**RE: Winterbourne Wind Farm Environmental Impact Statement (SSD-10471)**

## **Attachment 1: Detailed BCD and NPWS Comments – Winterbourne Wind Farm EIS**

The Biodiversity and Conservation Division (BCD) of the Department of Planning and Environment has reviewed the Environmental Impact Statement (EIS) including the Biodiversity Development Assessment Report (BDAR) for the Winterbourne Wind Farm prepared by NGH dated October 2022.

Figure 9 Identified point-to-point radiocommunication vectors crossing the Project and requested clearance zones (links 2 and 3)

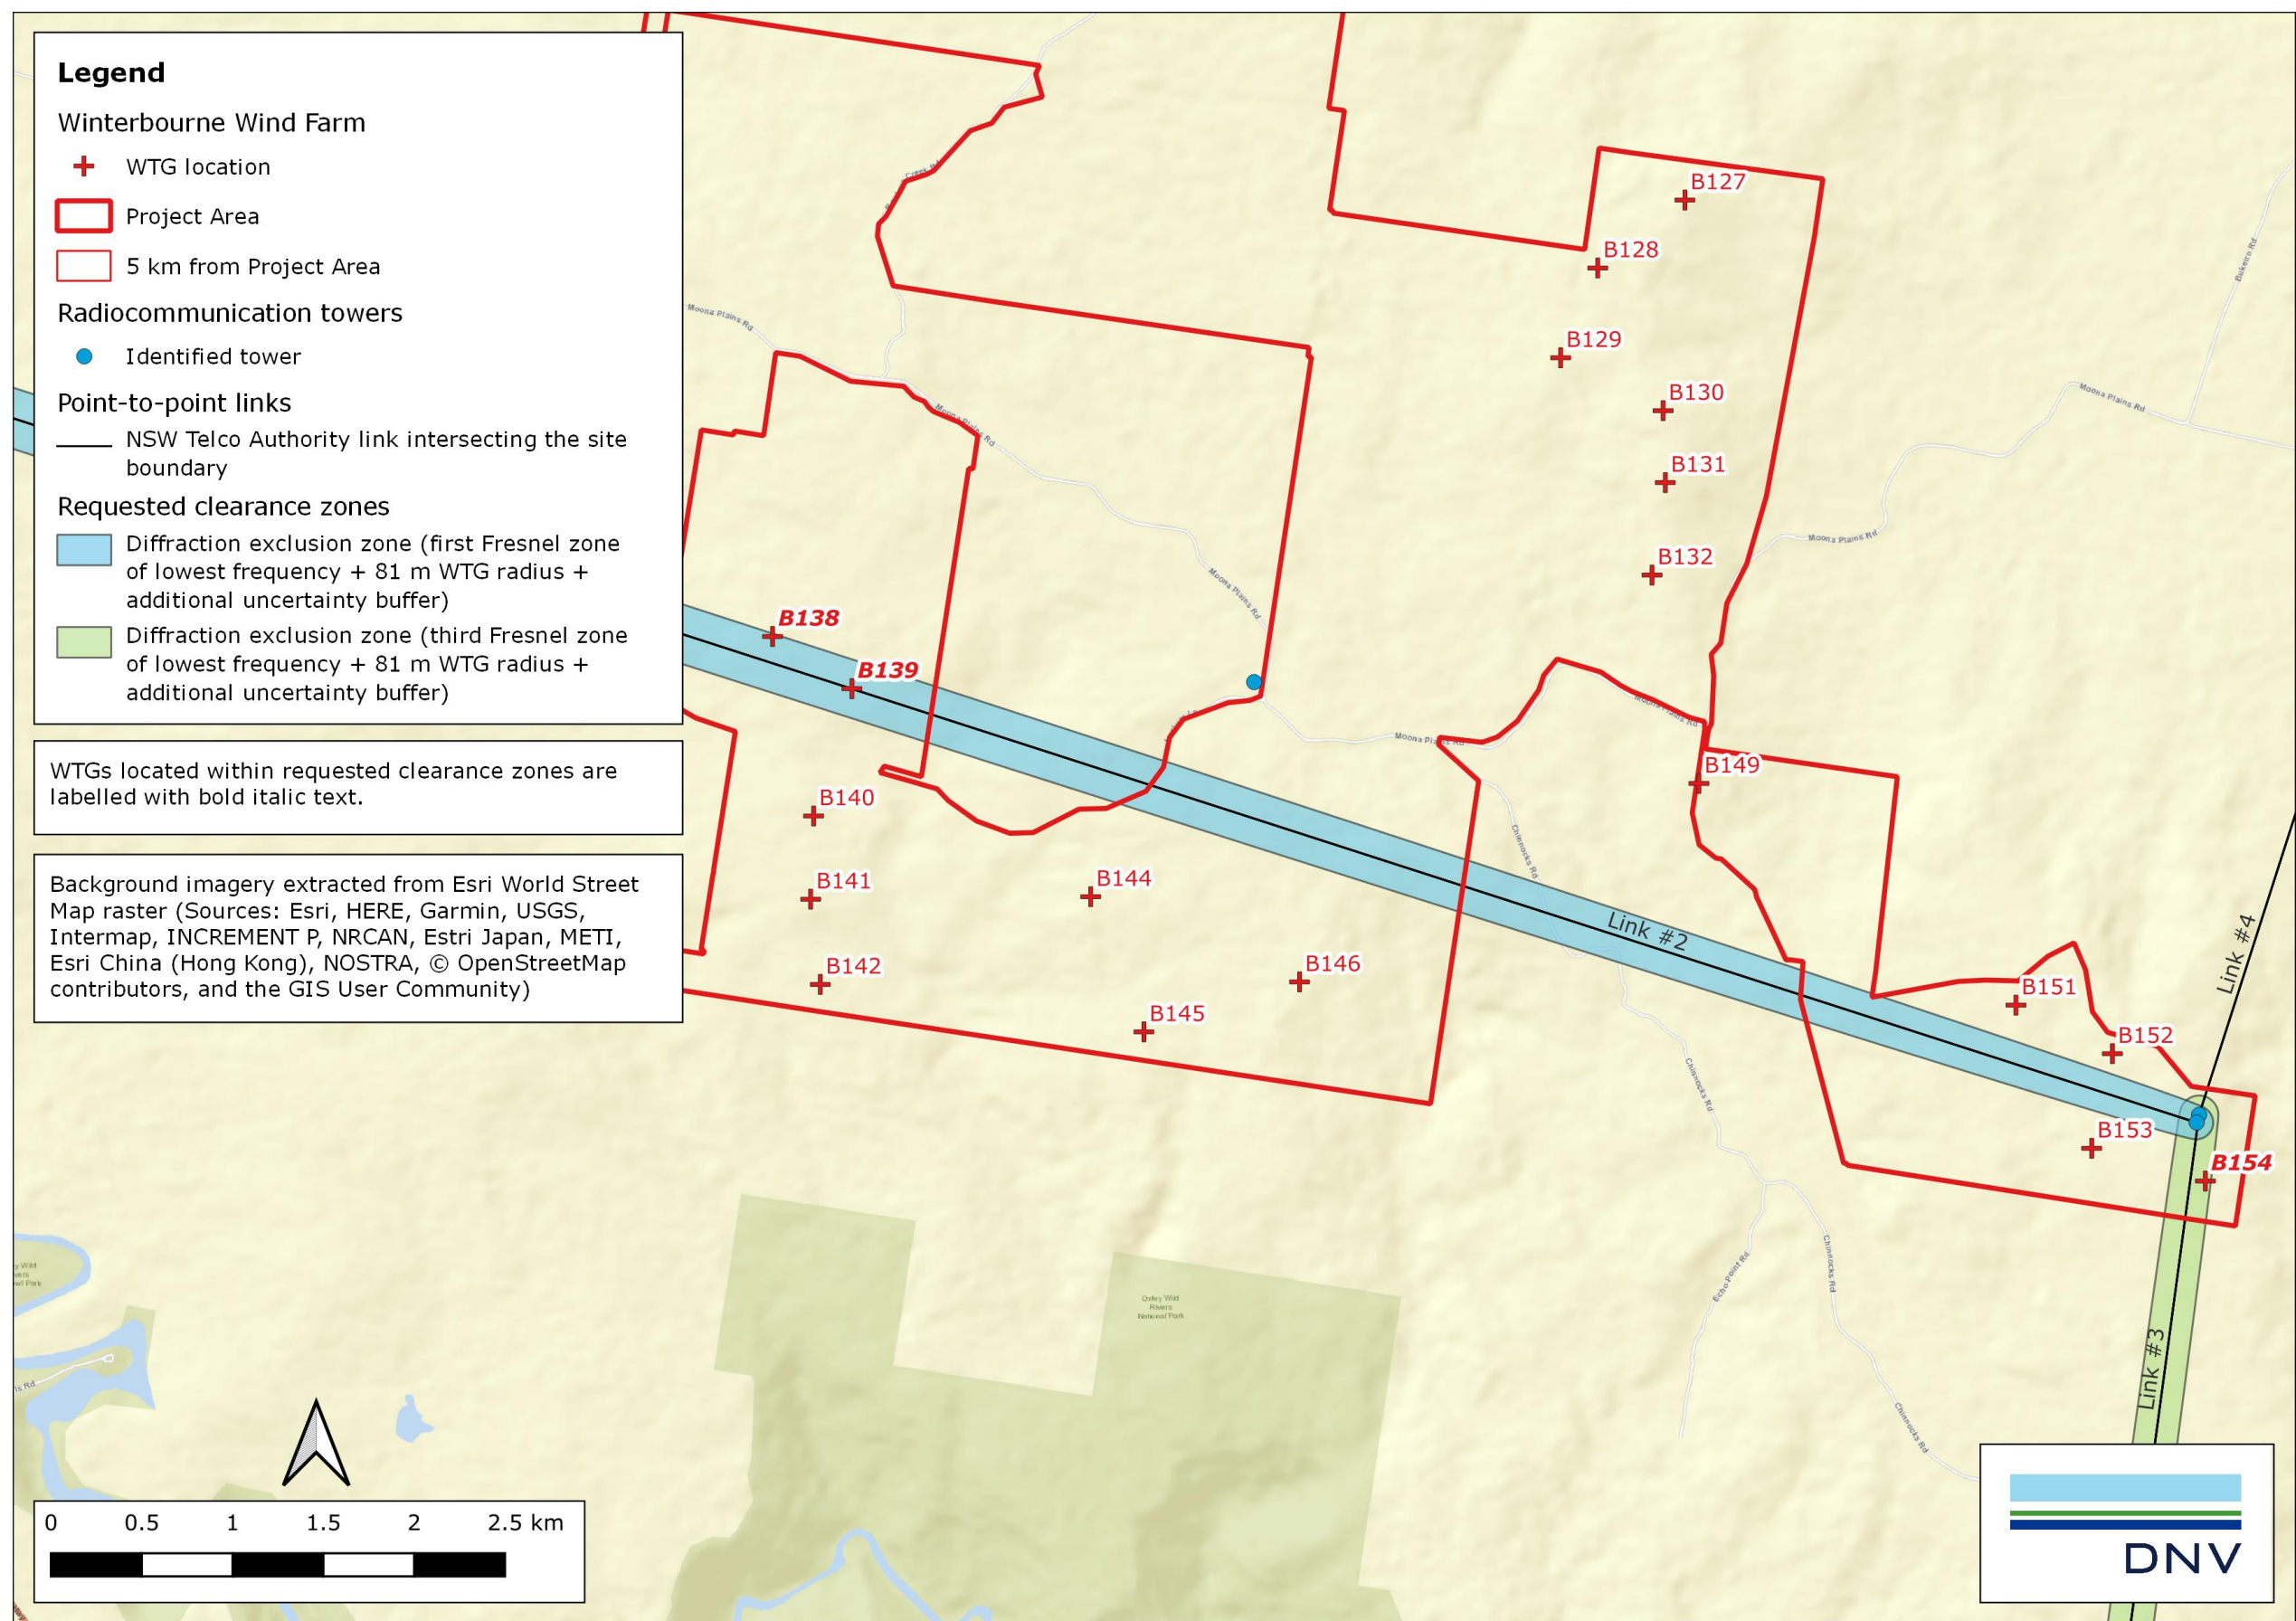
32. Turbines B071 and B073 must be relocated out of the interference zone of the NPWS point-to-point link as recommended in Appendix N of the EIS.
33. Conditions of consent must be included that require rectification of any issues with multipoint communications encountered in the first five years of the wind farm's operation.
